Phone: 0300 123 6780
Email: developeras@lancashire.gov.uk
Your ref: 3/2025/0790
Our ref: 3/2025/0790/HDC/KW
Date: 16 October 2025

Location: 56 Redwood Drive Longridge PR3 3HA
Proposal: Proposed single-storey side extension to provide garage.
Grid Ref: 360673 437828

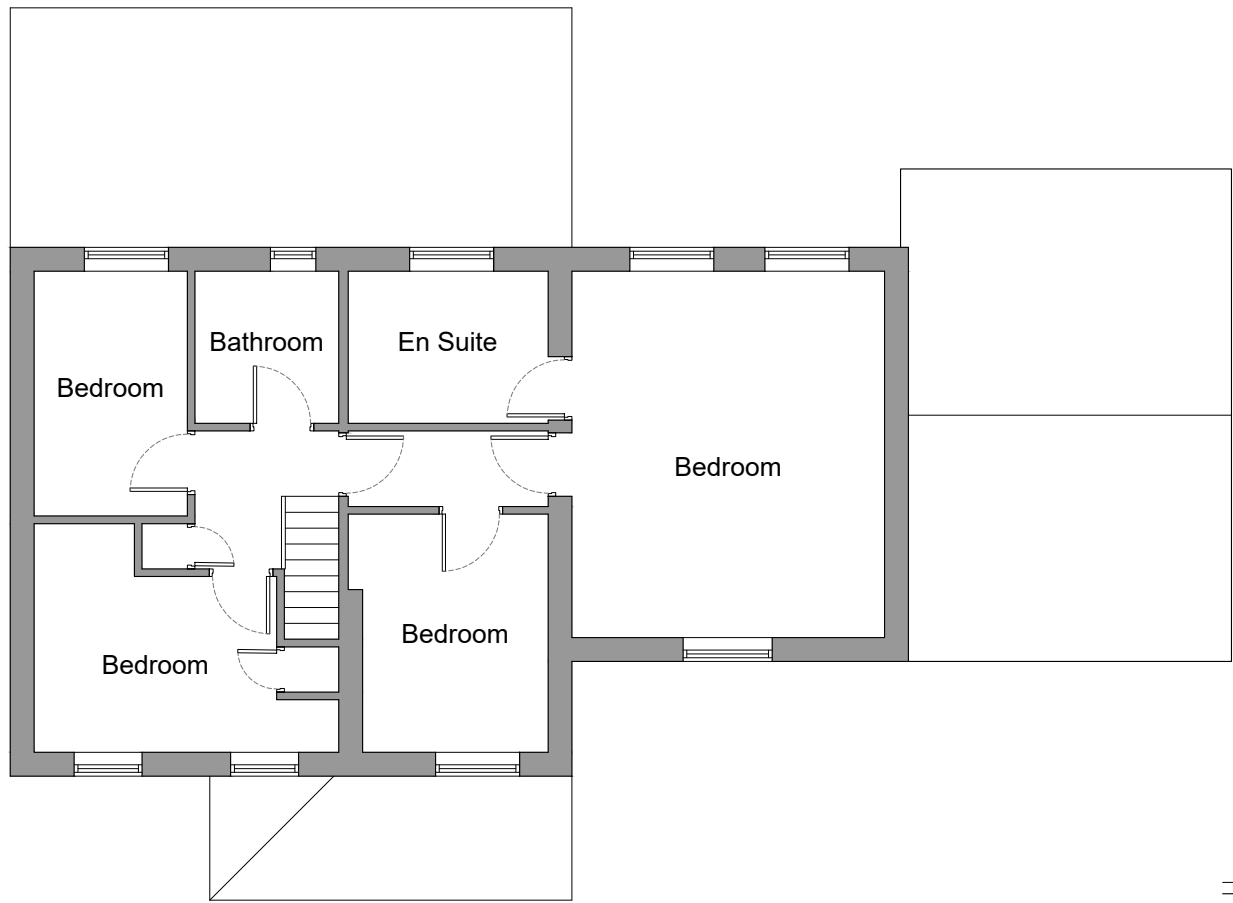
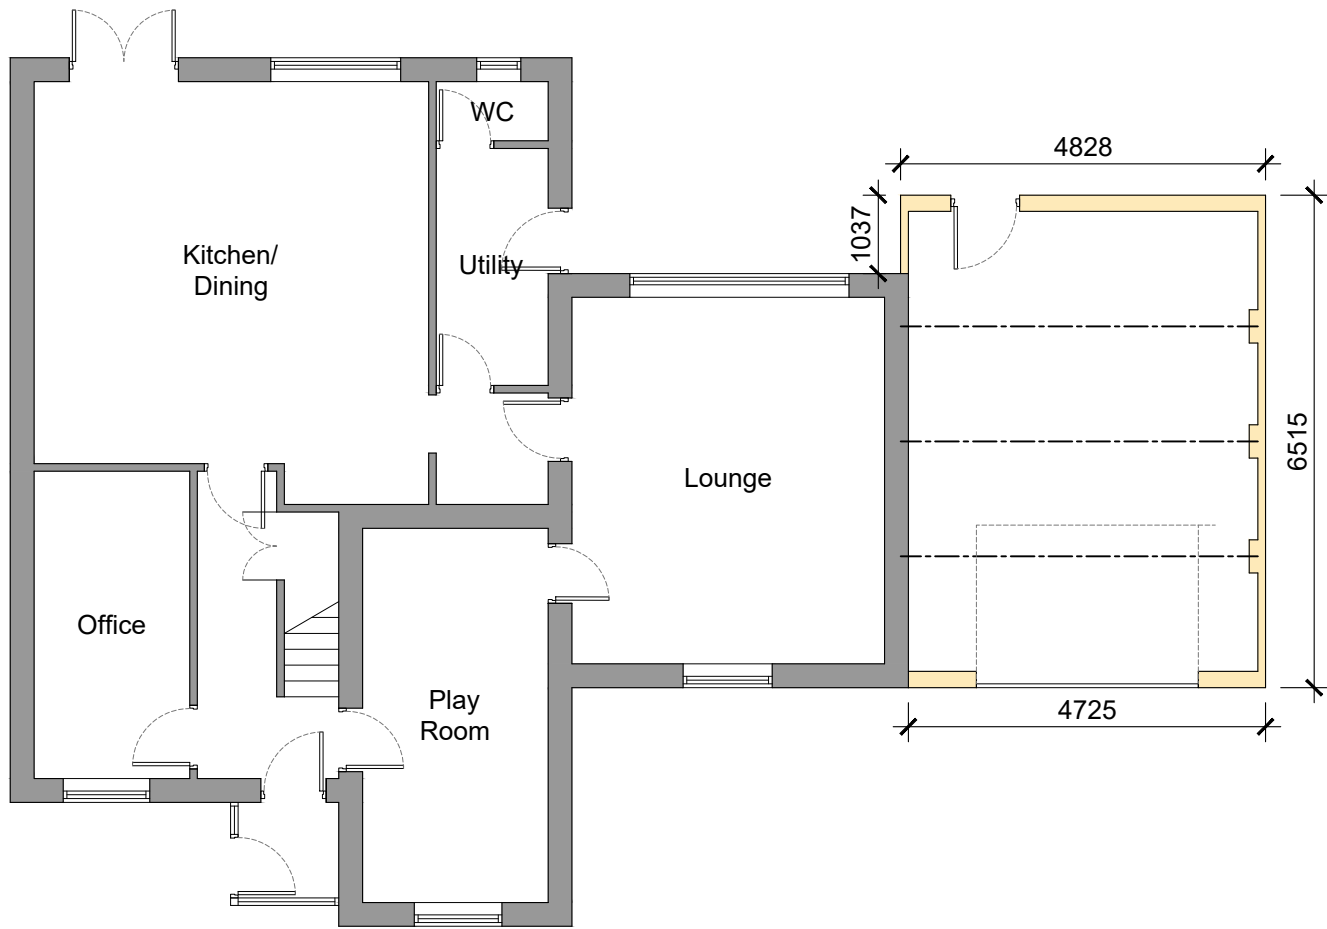
The LHA have reviewed PGB drawing number EAD_293_P_02 and is aware that the site access will remain unaltered following the proposal.

A 4-bedroom dwelling should provide at least 3 off-street parking spaces to ensure a negligible impact on highway safety and highway capacity within the immediate vicinity of the site. It is also recommended that all private drives fronting garages be a minimum of 6m long. The proposal includes an extension to the existing driveway to provide access to the new garage. The proposed garage meets the recommended minimum internal dimensions for a single garage size, which is 6m in length and 3m wide. The driveway will also provide parking for 3 vehicles; as such, the off-street parking provisions are acceptable to the Local Highway Authority.

1. Before the widened parking area is used for vehicular purposes, it shall be appropriately paved in tarmacadam, concrete, block pavements, or other hard material to be approved by the Local Planning Authority. **Reason:** To prevent
